CITY OF ALBUQUERQUE

July 30, 2019

Re: Dripline (Biergarten)
13202nd St NW
Traffic Circulation Layout
Engineer's/Architect's Stamp 06-14-2019 (J14D046)

TRAFFIC CIRCULATION LAYOUT PLAN

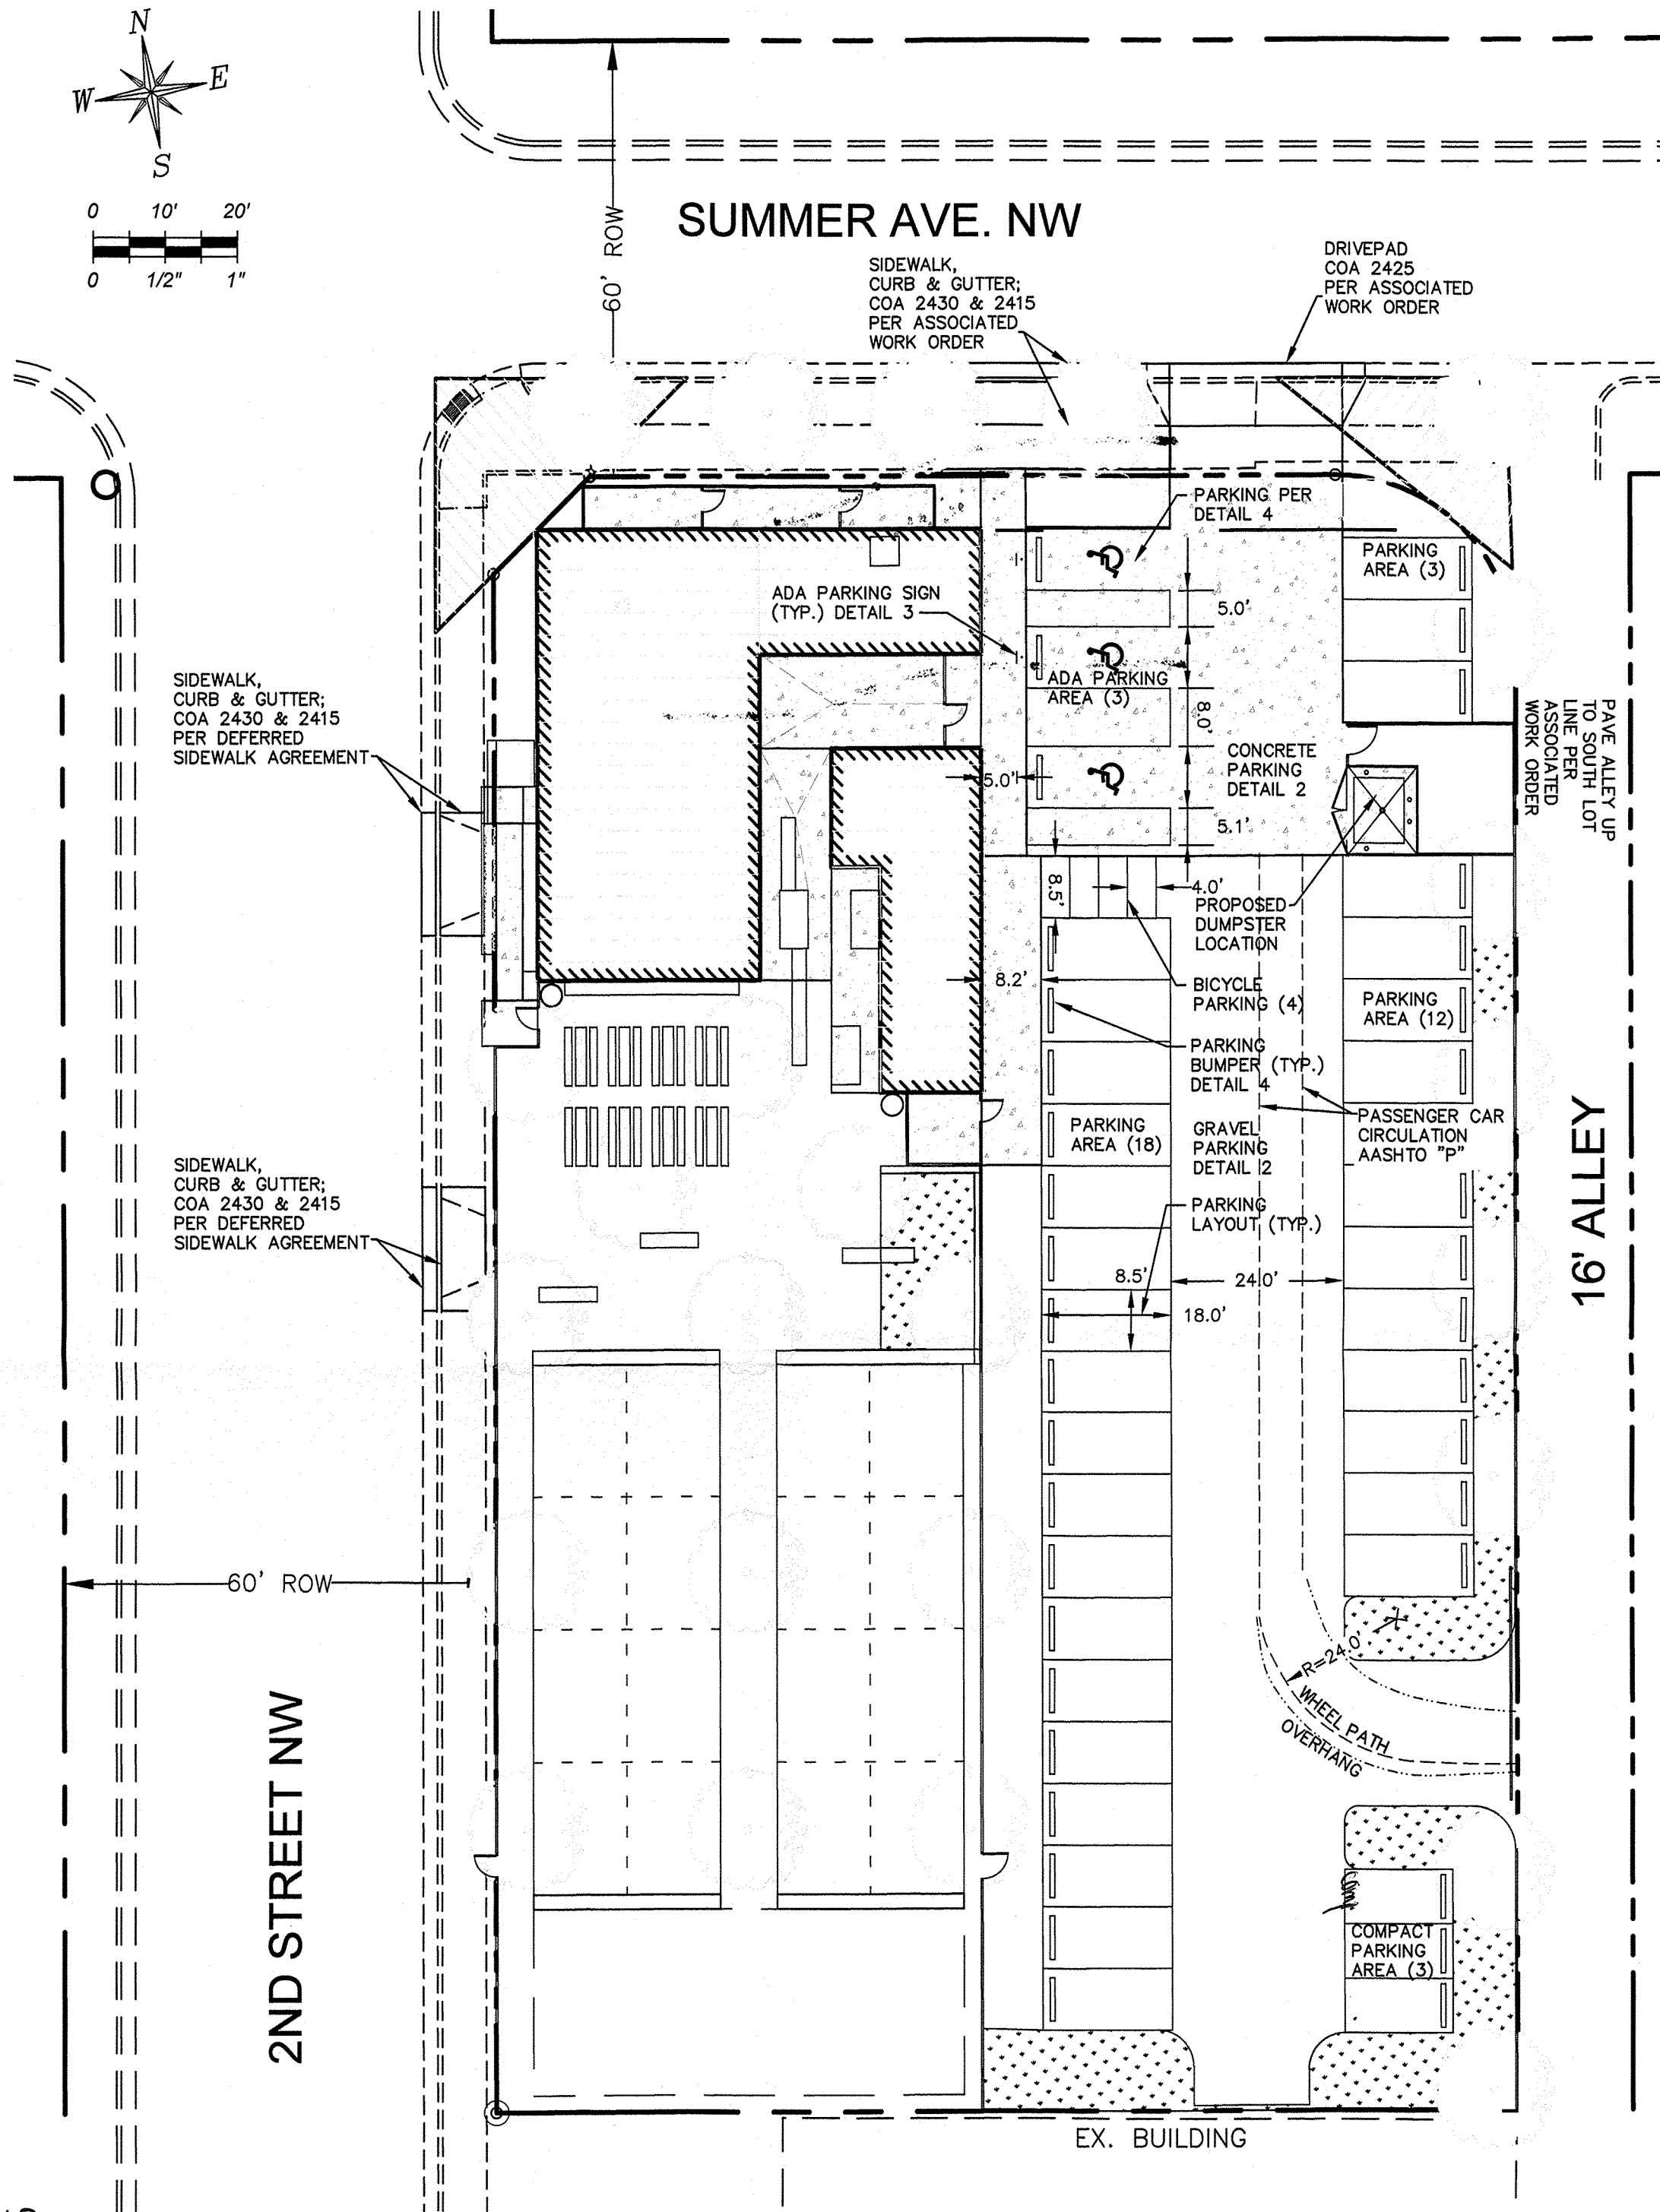
1. There are 3 different tables that show different number of required/provided parking spaces. Please verify the correct one.
2. Parking spaces cannot be bisected by lot lines.

3. A replat is required for this property. The property is divided into 9 lots which should be 1 lot.
4. The ADA accessible parking sign must have the required language per 66-7-352.4C NMSA 1978 **"Violators Are Subject to a Fine and/or Towing."** Please call out detail and location of signs.

5. All bicycle racks shall be designed according to the following guidelines:
 - a. The rack shall be a minimum 30 inches tall and 18 inches wide.
 - b. The bicycle frame shall be supported horizontally at two or more places. Comb/toaster racks are not allowed.

- c. The rack shall be designed to support the bicycle in an upright position. See the IDO for additional information.
 - d. The rack allows varying bicycle frame sizes and styles to be attached.

- e. The user is not required to lift the bicycle onto the bicycle rack.
 - f. Each bicycle parking space is accessible without moving another bicycle.

6. Bicycle racks shall be sturdy and anchored to a concrete pad.
7. A 1-foot clear zone around the bicycle parking stall shall be provided.
8. Bicycle parking spaces shall be at least 6 feet long and 2 feet wide.

9. provide a copy of refuse approval.
10. Unused curb cuts must be replaced with sidewalk and curb & gutter. A build note must be provided referring to the appropriate City Standard drawing.
11. Add a note stating "All broken or cracked sidewalk must be replaced with sidewalk and curb & gutter." A build note must be provided referring to the appropriate City Standard drawing.
